DRB Application No.: 09DRB-70384 Project # 1004998
Project Name: New Mexico School for the Blind and Visually Impaired
Agent: Forstbauer Surveying Co. LLC Phone No.:

DEVELOPMENT REVIEW BOARD--SPEED MEMO

**RE: Tract H-1, Manzano Mesa and Tract L, Sandia Science
and Technology Park**

Site Sketch  
Tract H-1-A & H-1-B  
Manzano Mesa  
Bernalillo County, New Mexico  
City of Albuquerque

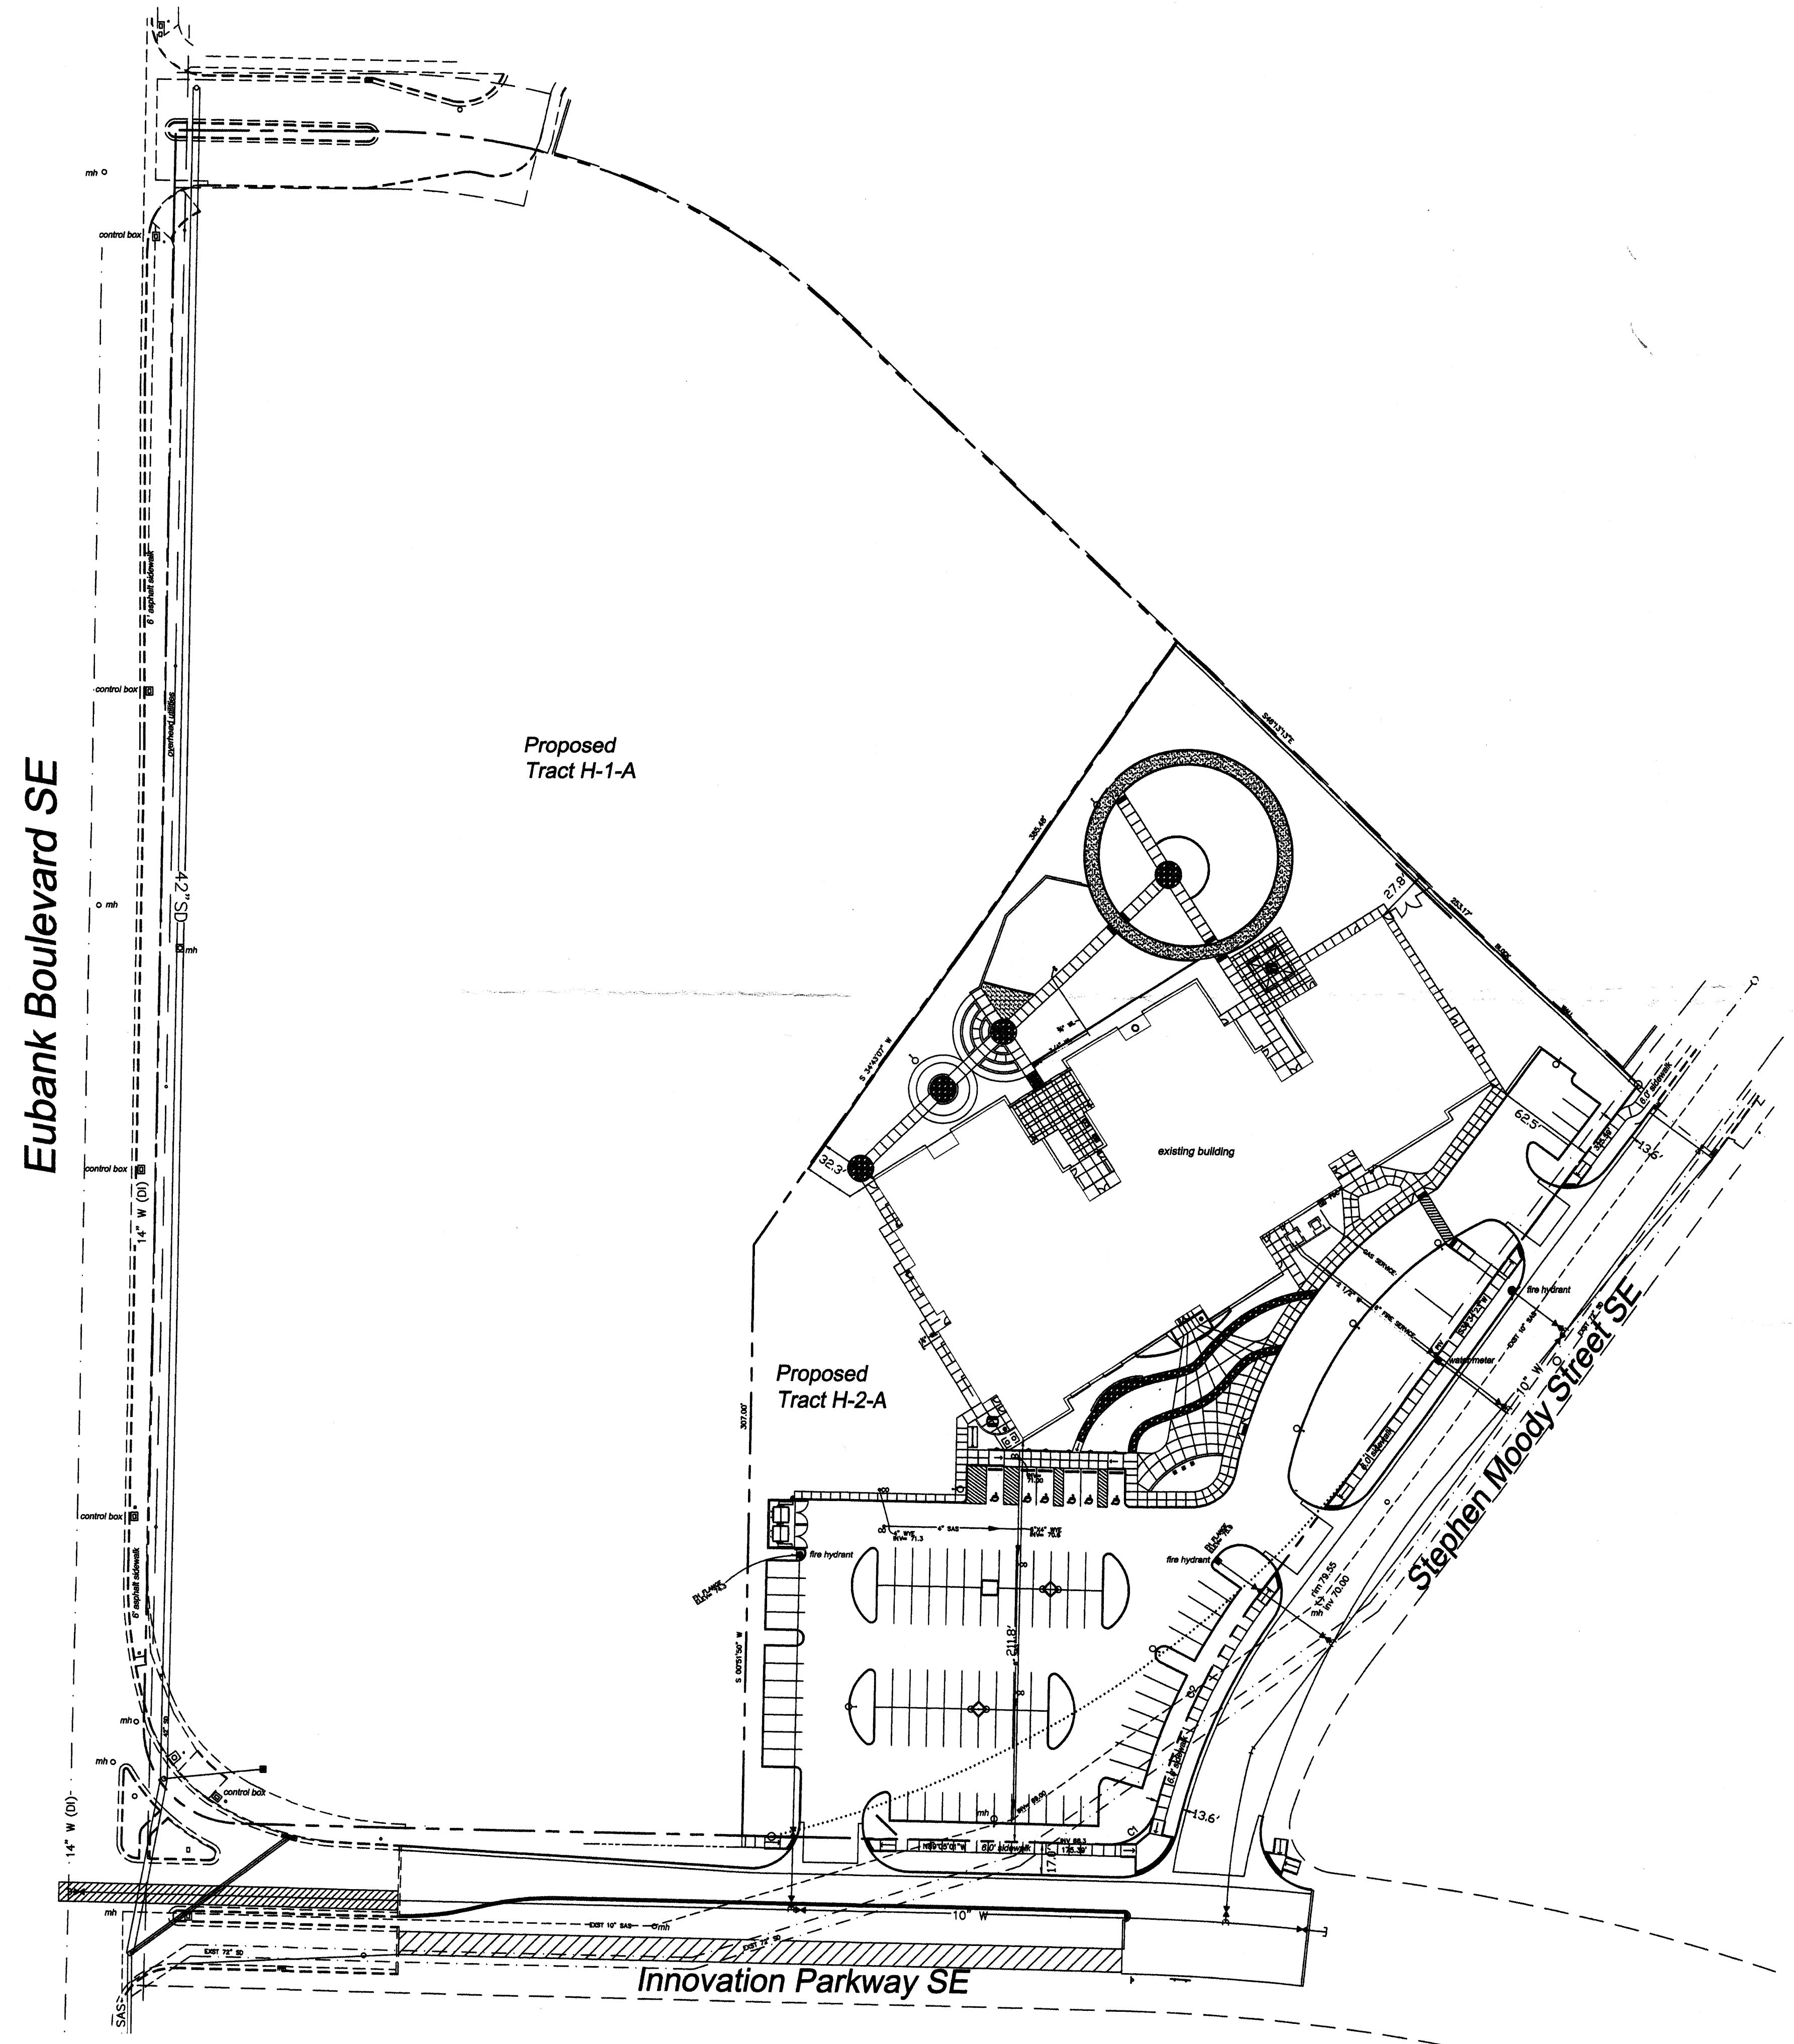
Need storm drain easement called out on what was once Tract L.

For future reference, please remove zoning note from final plat.

A continuation of the 10 foot Public Utility Easement is needed around the perimeter of the subdivision, and inside the sidewalk at the intersection of Eubank Blvd and Innovation Pkwy.
